RE: SUB19-002/SEP19-005 – Proposed Preliminary Plat  
2825 W. Mercer Way, APN 2174502425  
Request for Additional Information, Third Review  
Blueline Job No. 13-118

This letter is in response to your review of the SUB19-002/SEP19-005 project. The plans have been revised per the comments in your letter dated 1/09/23. Below is a list of each comment with our responses in bold.

2/16/23
 JOB NUMBER:
13-118
 SHEET NAME:
CV-01
 SHT 1 OF 9

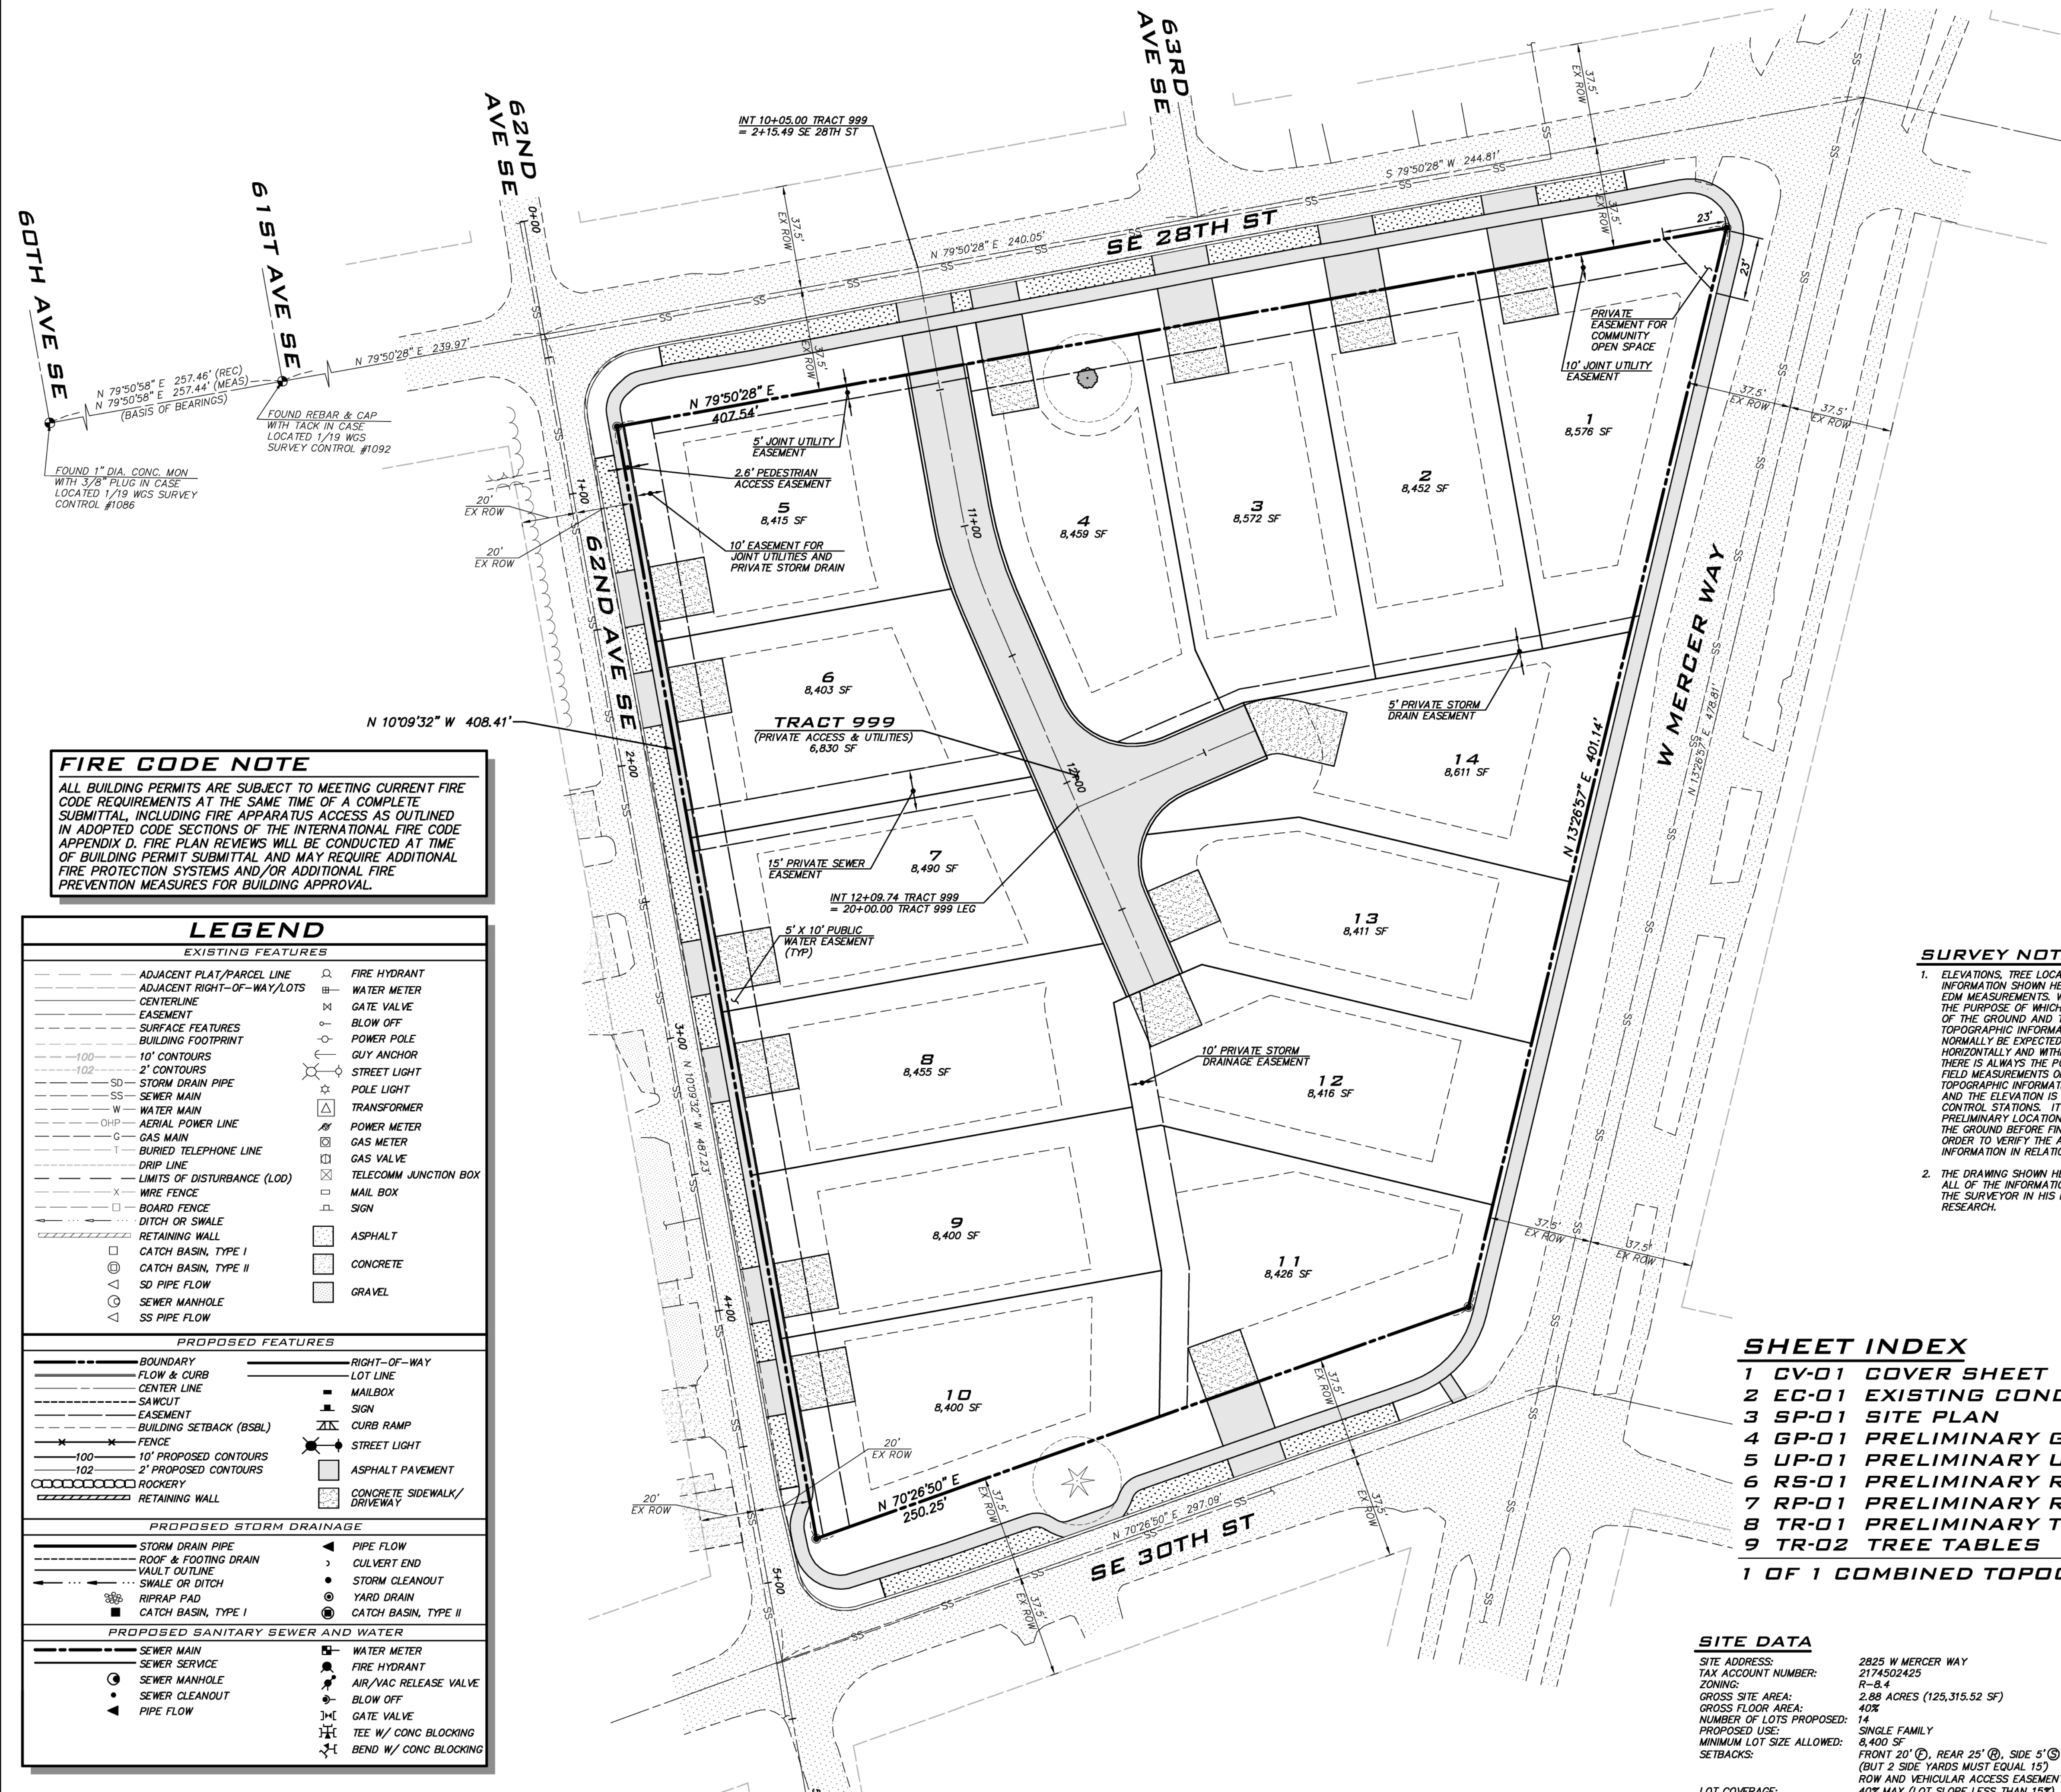
*Plat Map Note - Please include this note on your plat map.*

*"All building permits are subject to meeting current fire code requirements at the time of a complete submittal, including fire apparatus access as outlined in adopted code sections of the International Fire Code Appendix D. Fire plan reviews will be conducted at time of building permit submittal and may require additional fire protection systems and/or additional fire prevention measures for building approval."*

**This note has been added to sheet CV-01.**

2/16/23
 JOB NUMBER:
13-118
 SHEET NAME:
SP-01
 SHT **3** OF **9**

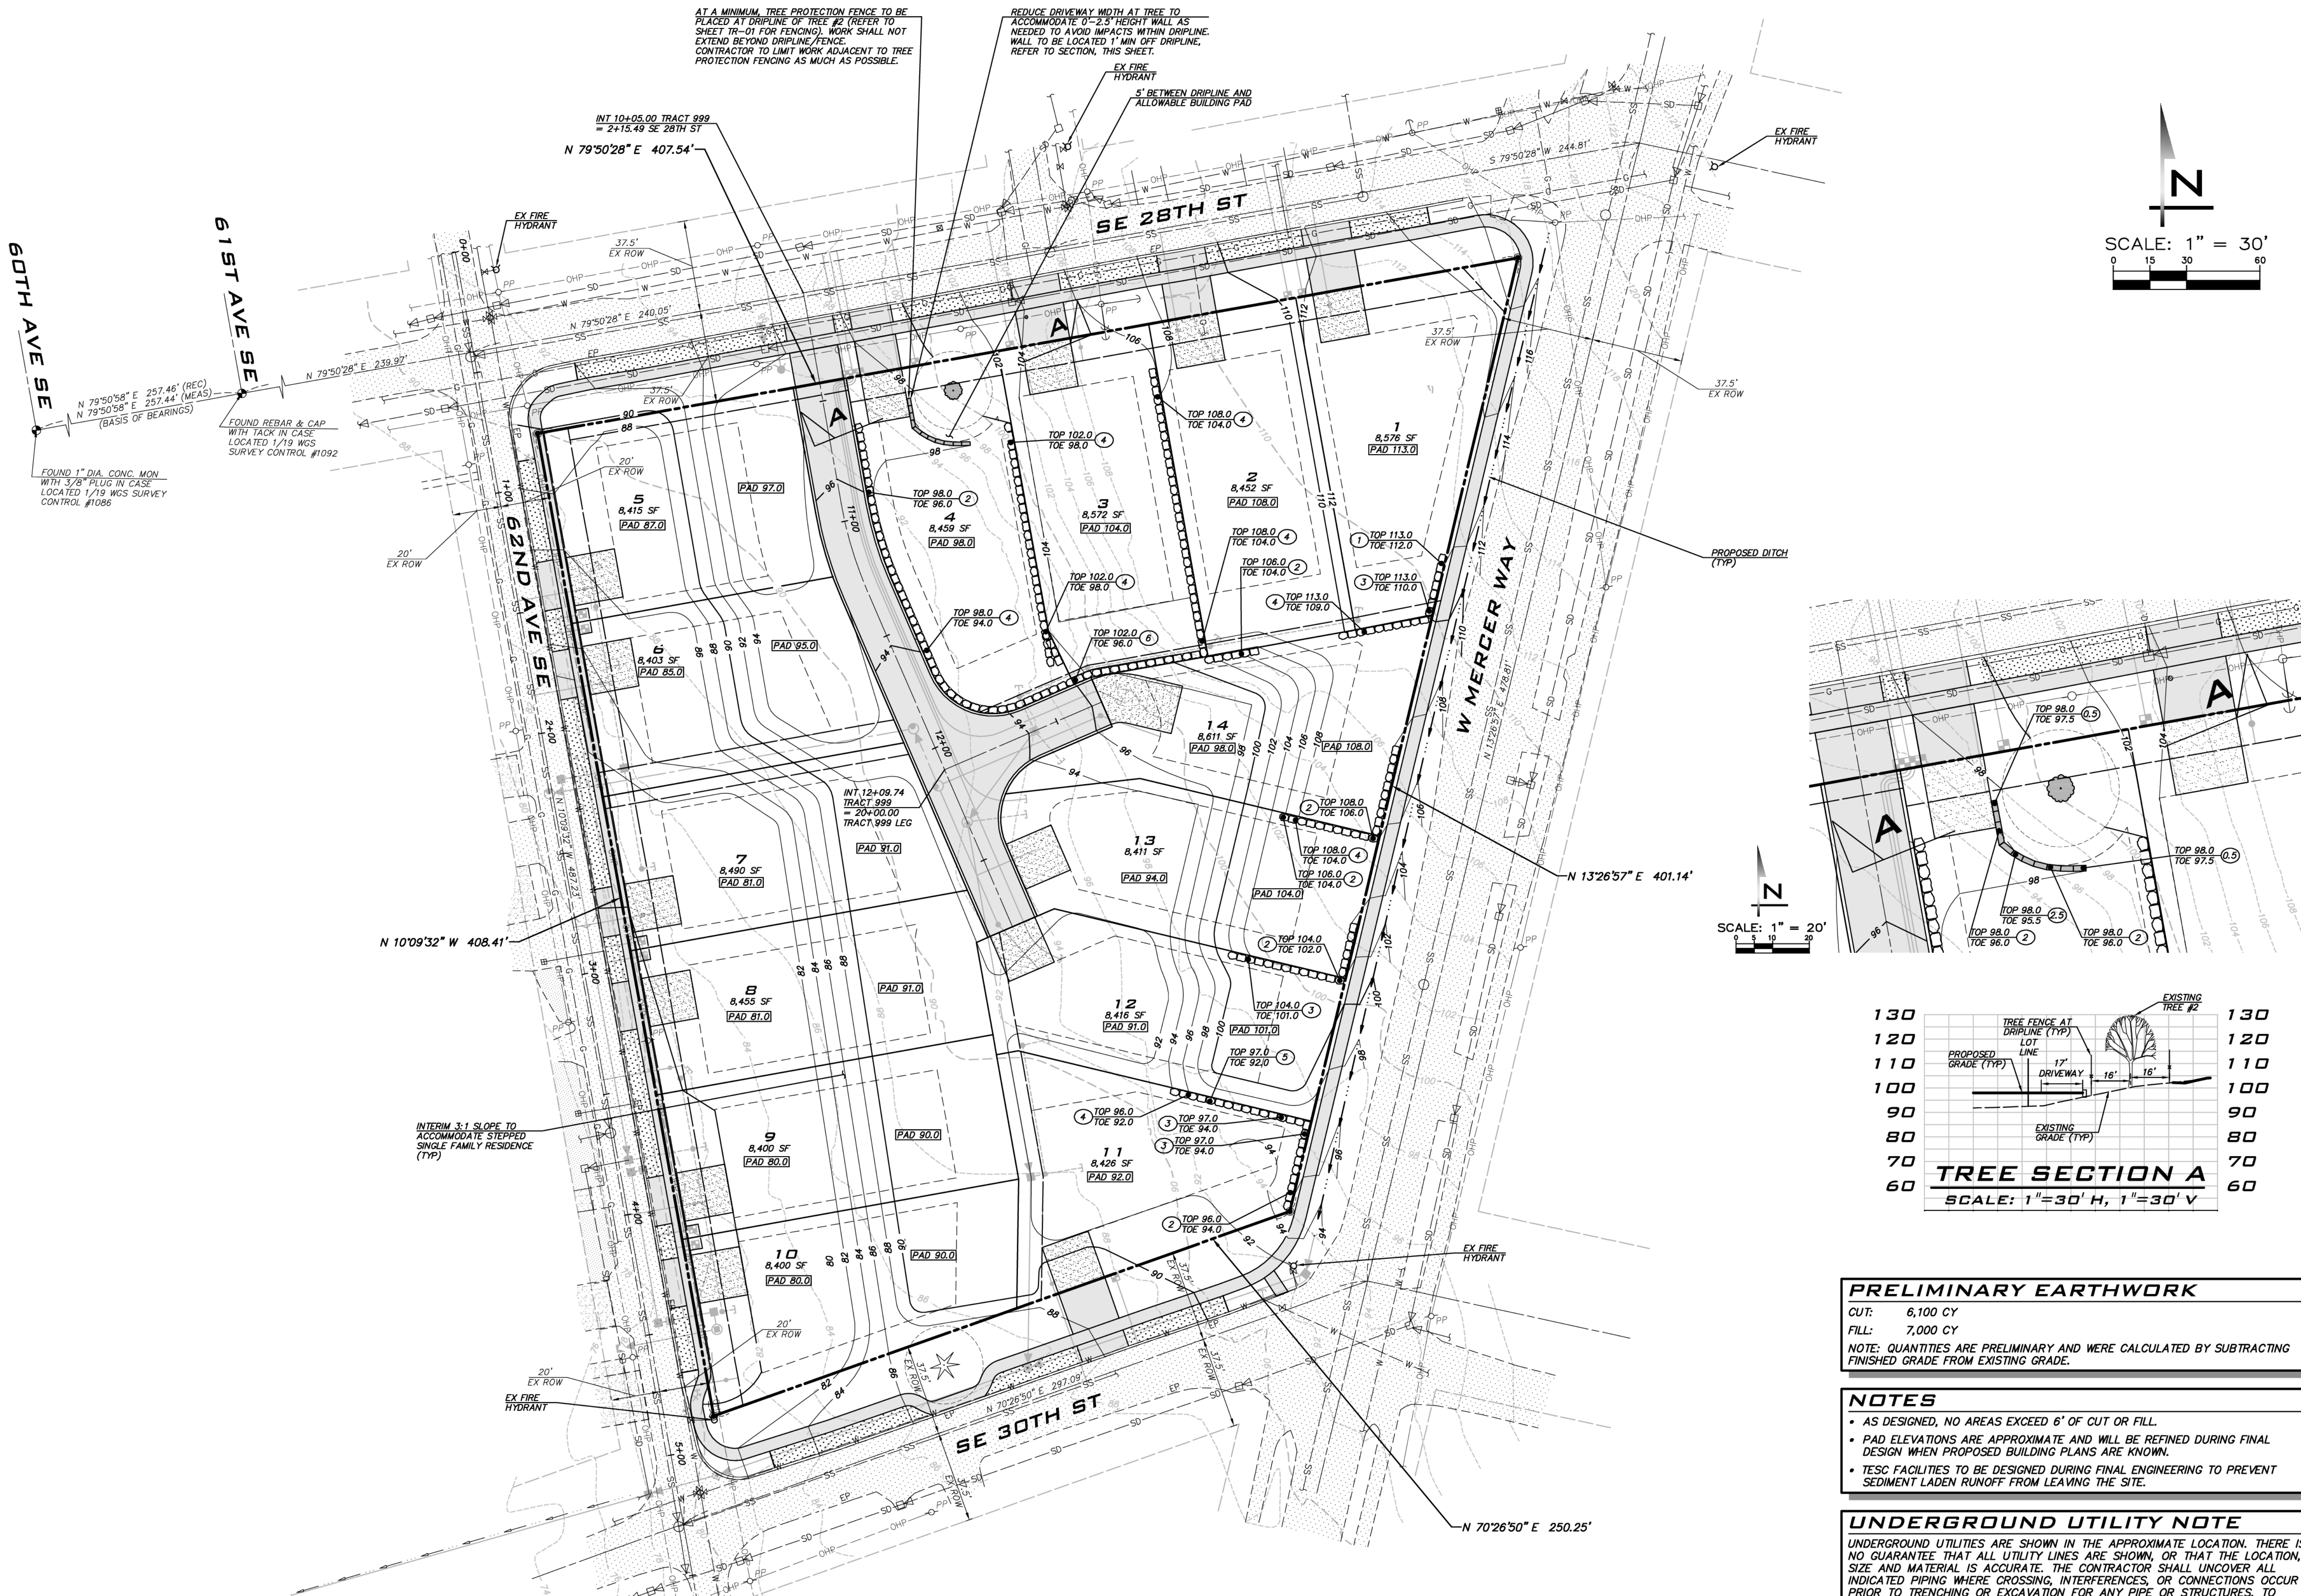
4. The sidewalk along SE 28th Street needs to be located, so the existing catch basins will not be in the middle of the sidewalk or relocate the existing storm drainage system on SE 28th Street.

**Per meeting with the City on 1/26/23, the public storm system along SE 28<sup>th</sup> St has been updated and that will need to be reflected in the drawings for the Site Development Permit. A callout has been added to sheet SP-01 for the asphalt path to jog as needed to avoid existing catch basins.**

5. All sidewalks must be ADA compliance.

**A note for ADA compliance has been added to sheet SP-01. Additional detail to be provided with the Site Development Permit.**

1. The sidewalk at the southwest of the intersection (W. Mercer Way and SE 28th Street) has too many turns and not ADA compliance. The sidewalk is too close to the PSE guy wire. A section of the property shall be dedicated to the City as ROW to accommodate the public sidewalk.

**The asphalt path layout at the SW corner of the intersection of W Mercer Way and SE 28th St has been revised. Per email correspondence with the City on 2/10/23, the revised layout at this intersection will be sufficient for the preliminary plat and the detailed design of the paths around the frontage will be reviewed under the Site Development Permit. A callout has been added for the guy wire to be relocated as needed. The revised layout at this intersection provides a minimum of 6" behind the asphalt path for maintenance, and as such, an easement/additional ROW is not needed. This layout will be confirmed following construction to ensure a minimum of 6" is provided behind the asphalt path, otherwise, an easement/additional ROW will be needed.**
